Tween Bridge Solar Farm

Environmental Statement Chapter 10: Water Resource

Document Reference: 6.2.10

Revision ~~1~~2

### Non-Intrusive Cable Crossing – Watercourse/IDB Drain/Main River/Canal

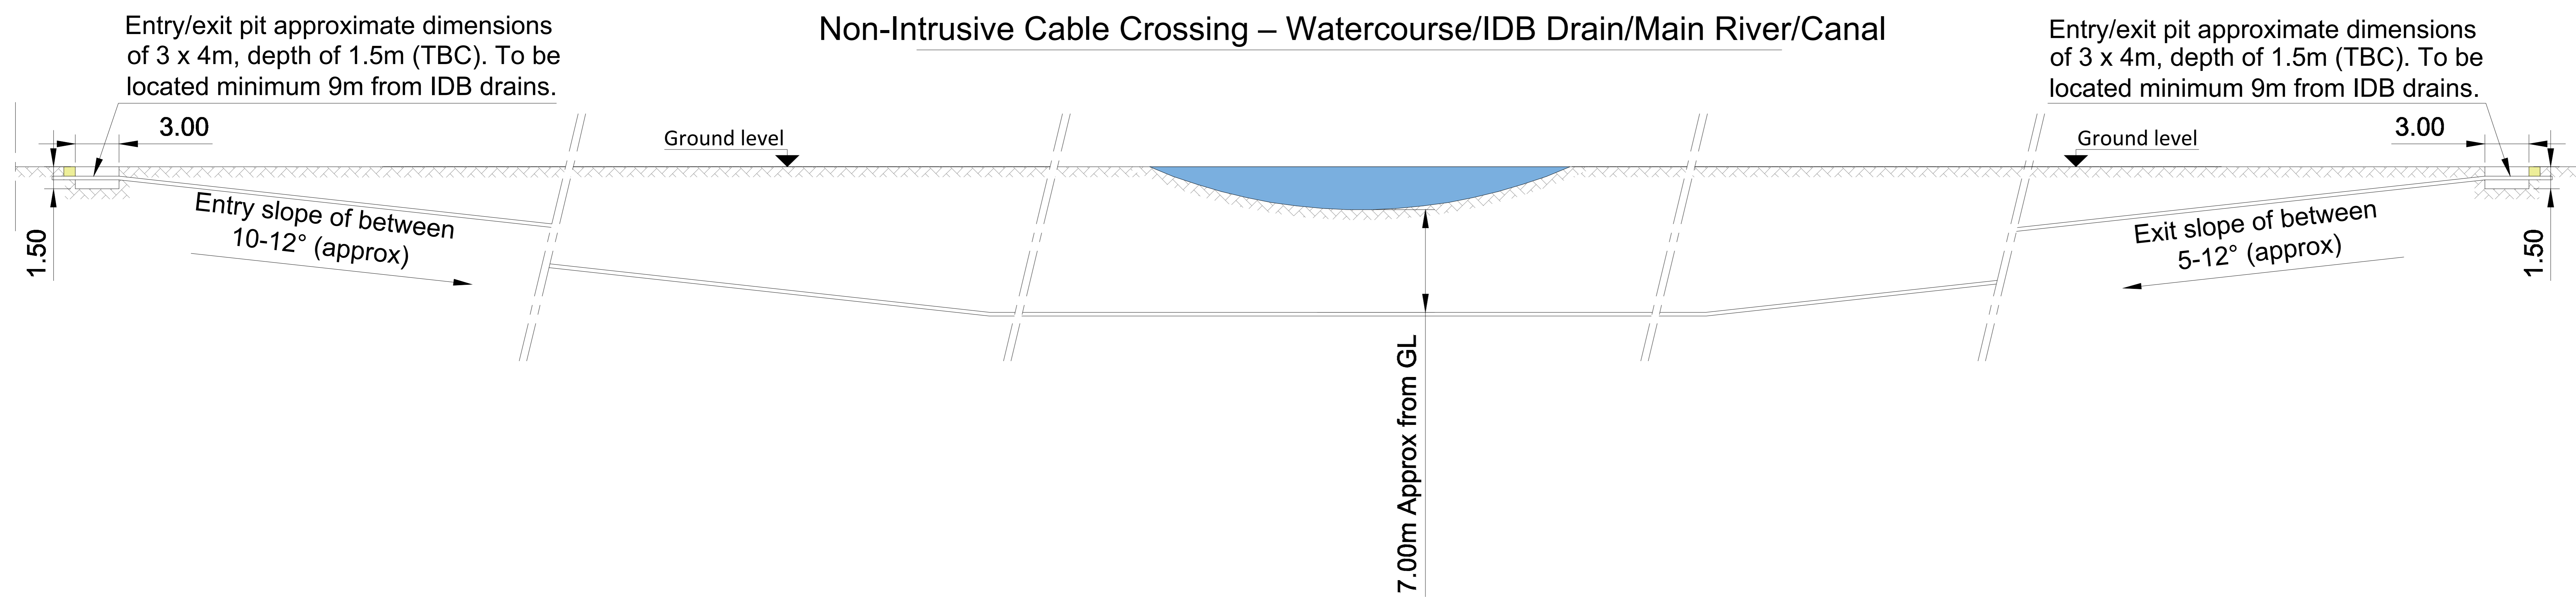
<p>application to ensure compliance with flood and environmental protection standards.</p> <p>Flood Risk Activity Permits may be required for any directional drilling beneath main rivers or watercourses.</p> <p>Fencing that crosses watercourses must be maintained to avoid debris build-up, which can obstruct flow. A maintenance plan should be established to ensure regular inspections.”</p>	<p>Drainage Strategy is included in the appended FRA (ES Appendix 10.1 Flood Risk Assessment [Document Reference 6.3.10.1 <u>Document Reference: 6.3.10.1 Revision 3</u>]). Full details of the proposed drainage will be confirmed during detailed design post-consent of the DCO application. During this stage, an assessment on the suitability of above ground SuDS will be carried out when full details of the proposals are available. More detailed network calculations would also be prepared during detailed design.</p> <p>The Outline Construction Environmental Management Plan [Document Reference 7.1 <u>Revision 3</u>] has been prepared as a stand alone document to assess the impact of construction activities.</p>

<p><u>Reference: 6.3.10.1 Revision 3]</u>).</p> <ul style="list-style-type: none">• Byelaw 17: The provisions of any byelaws made under section 66 of the Land Drainage Act 1991 and paragraphs 5, 6 or 6A of Schedule 25 to the Water Resources Act are disapplied under article 9 of the draft DCO [Document Reference 3.1] with protective provisions included in Schedule 14 of the draft DCO for the drainage authorities. This means that byelaw consents will not be required to be obtained post-consent. <p>ES Figure 2.4 Indicative HDD Crossing Plan [Document Reference 6.4.2.4APP-137]" highlights where HDD is proposed</p>
--	--	--

<p>within the Order Limits. Directional drilling is proposed for Main Rivers, Internal Drainage Board Watercourses and the Canal. Where HDD is not used, the proposed culverting methodology will ensure flood risk is not negatively impacted. The proposed culverting does not pose any engineering concerns.</p>
<p>South Yorkshire Fire and Rescue (SYFR)</p>	<p>“In the event of a fire involving BESS, it is likely that SYFR will need to apply a higher than average volume of water to restrict fire spread. Please ensure that there is an adequate water supply within 90m to allow continuous firefighting operations to take place; please also ensure due consideration has been given to containing fire water run-off.”</p>	<p>ES Figure 2.6 Indicative Layouts and Cross Section Plans [Document Reference 6.4.2.6][APP-139] includes a “Typical 100MW BESS Layout”. The typical Battery Energy Storage Systems (BESS) layout shows four water tanks which are to supply fire suppression water. During detailed design post-consent of the DCO application, the BESS design will be reviewed and updated as needed to ensure</p>
